84 Farragut St.
Road Extension
Archie Giobbi

**CITY OF PORTLAND, MAINE
DEVELOPMENT REVIEW APPLICATION
PLANNING DEPARTMENT PROCESSING FORM
Engineering Copy**

PUBLIC WORKS ENGINEERING REVIEW....3/18/03

I have reviewed the submittal dated 2/21/03 and offer the following comments:

16 PRECAST CONCRETE CATCH BASIN - TYPE "E"
NOT TO SCALE

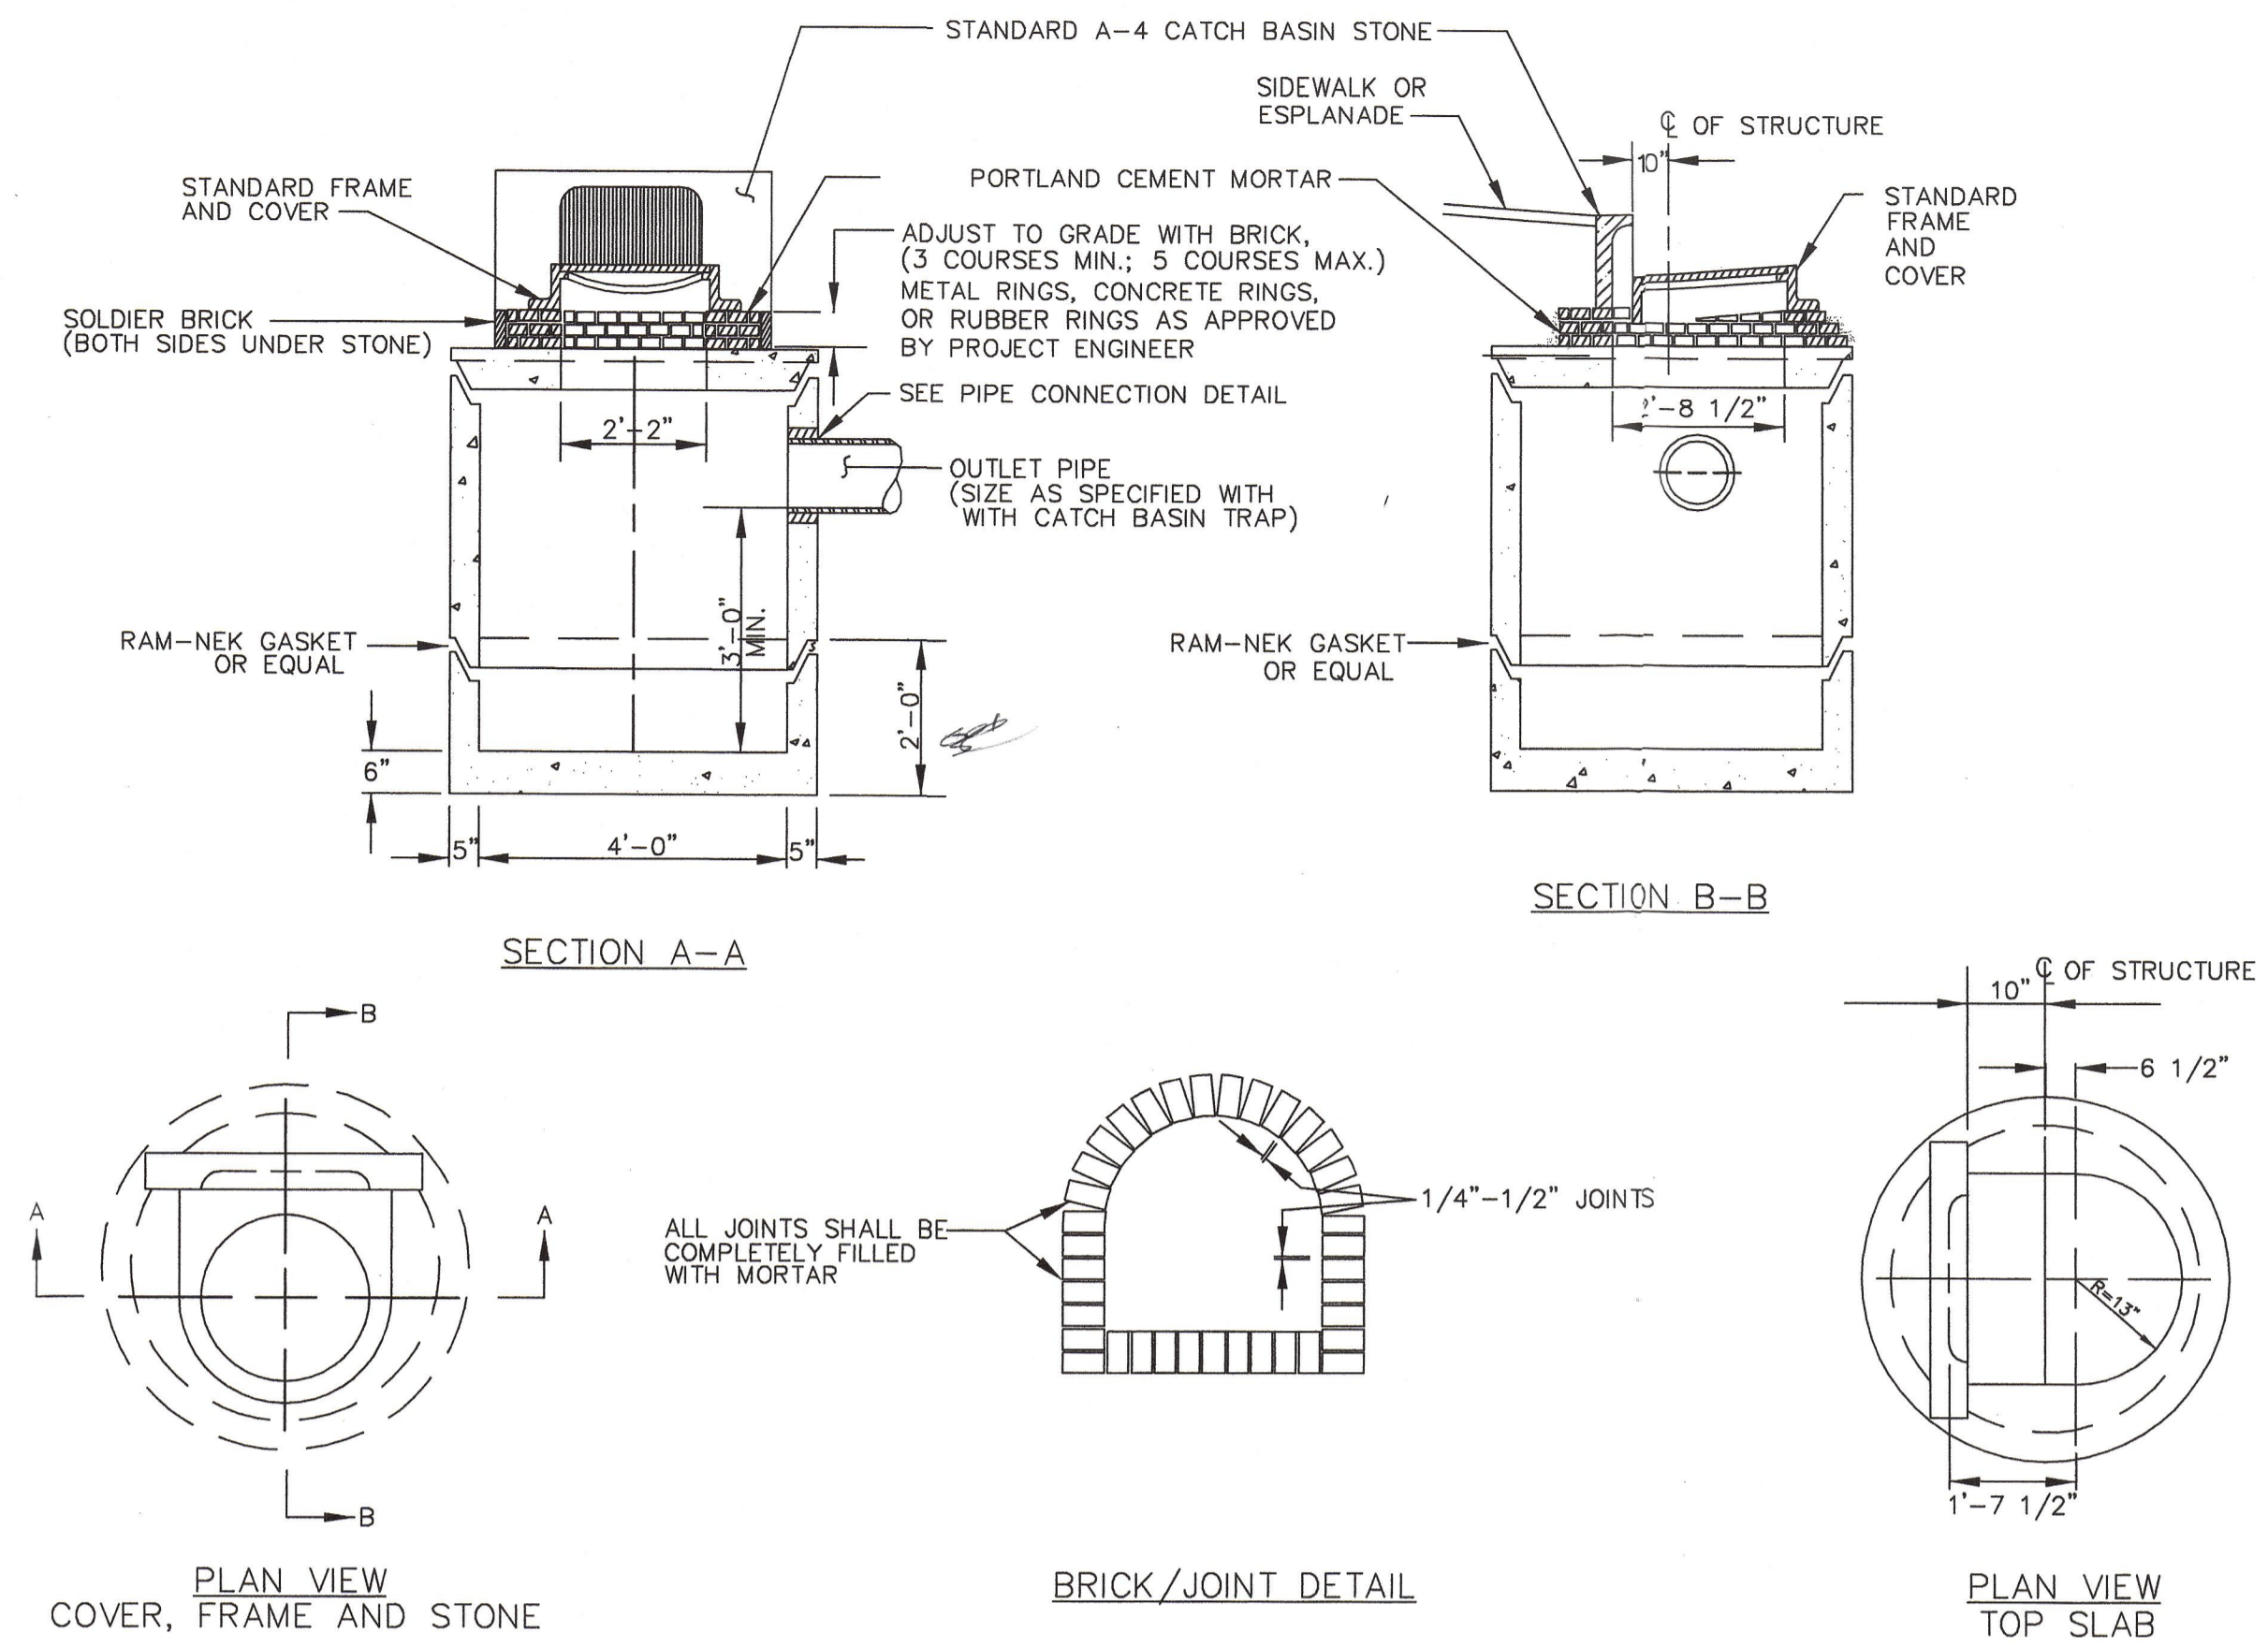
2. The plans need to specify details of the City's Technical Standard for a Type "E" catch basin structure; granite curb installation; "casco" trap for catch basin; driveway apron.

15 CASCO TRAP DETAIL
NOT TO SCALE

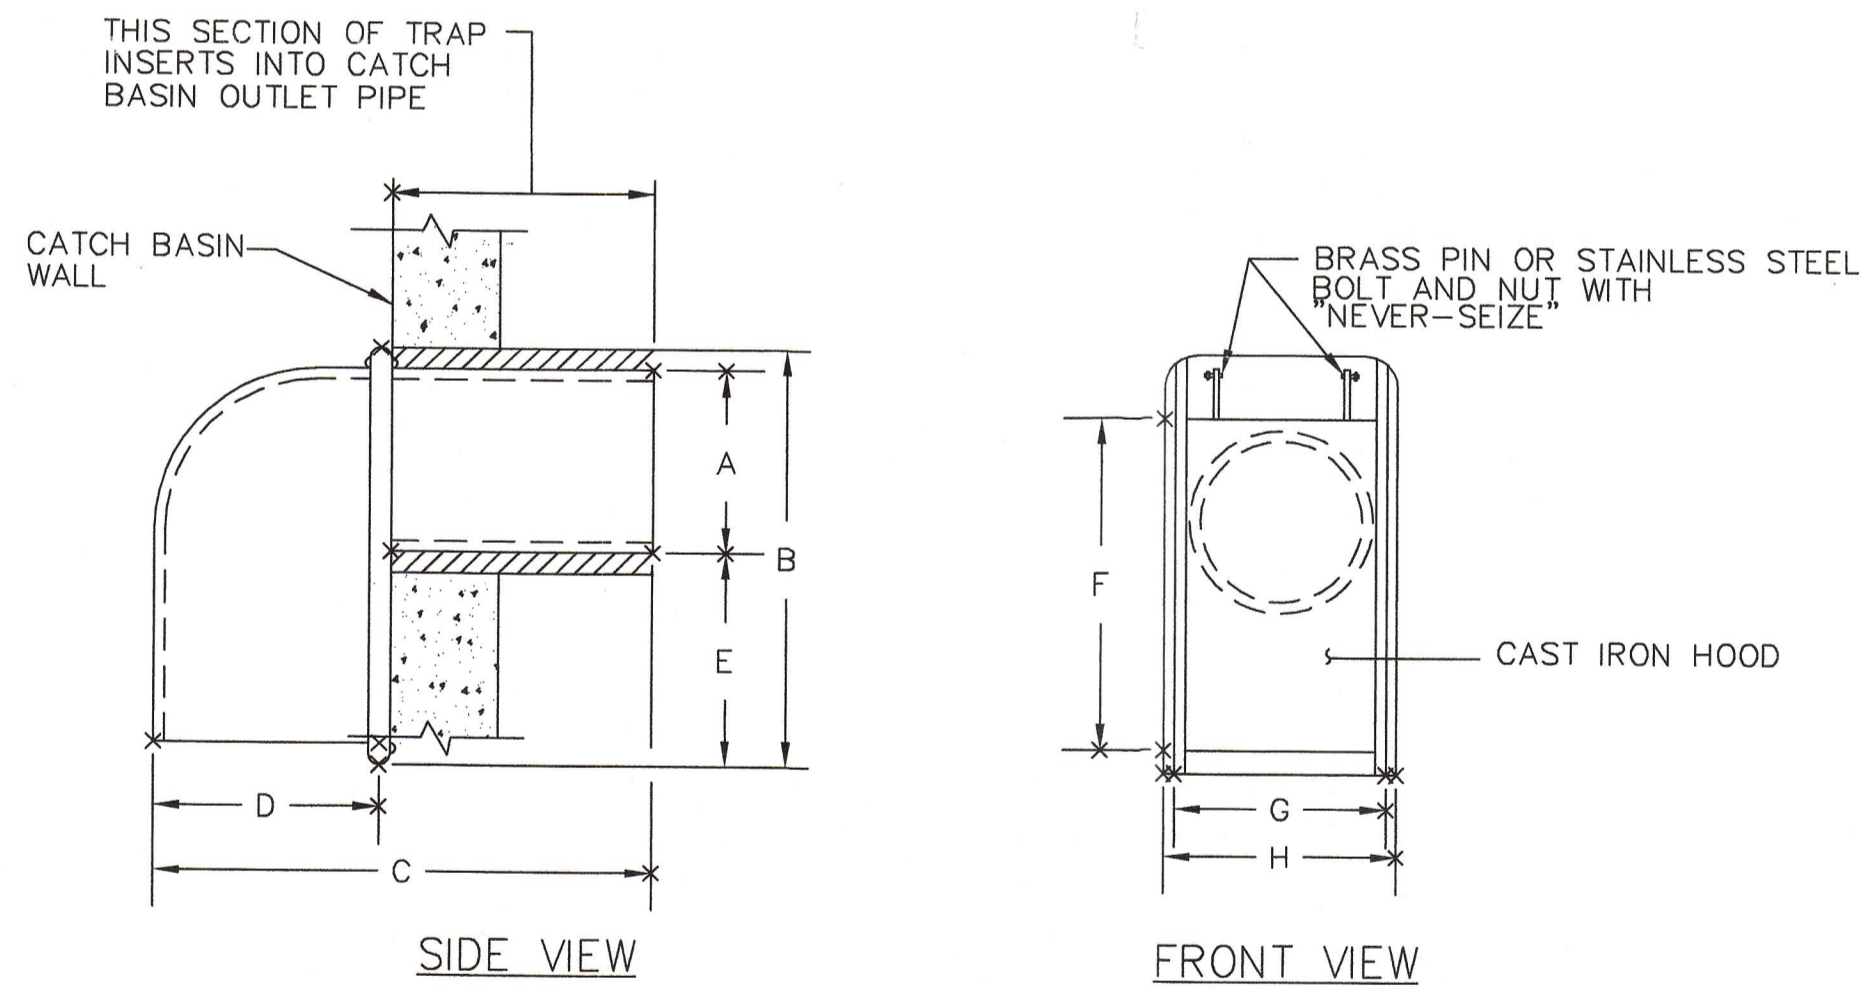
3. It should be noted on the plans that both CB#1 and CB#2 will be fitted with the appropriately sized "casco" catch basin trap.
4. The proposed driveway entrances need to be revised to conform with the City's Technical Standard. The terminal ends of each driveway entrance should be 2 feet wider at the gutter line than at the property line.
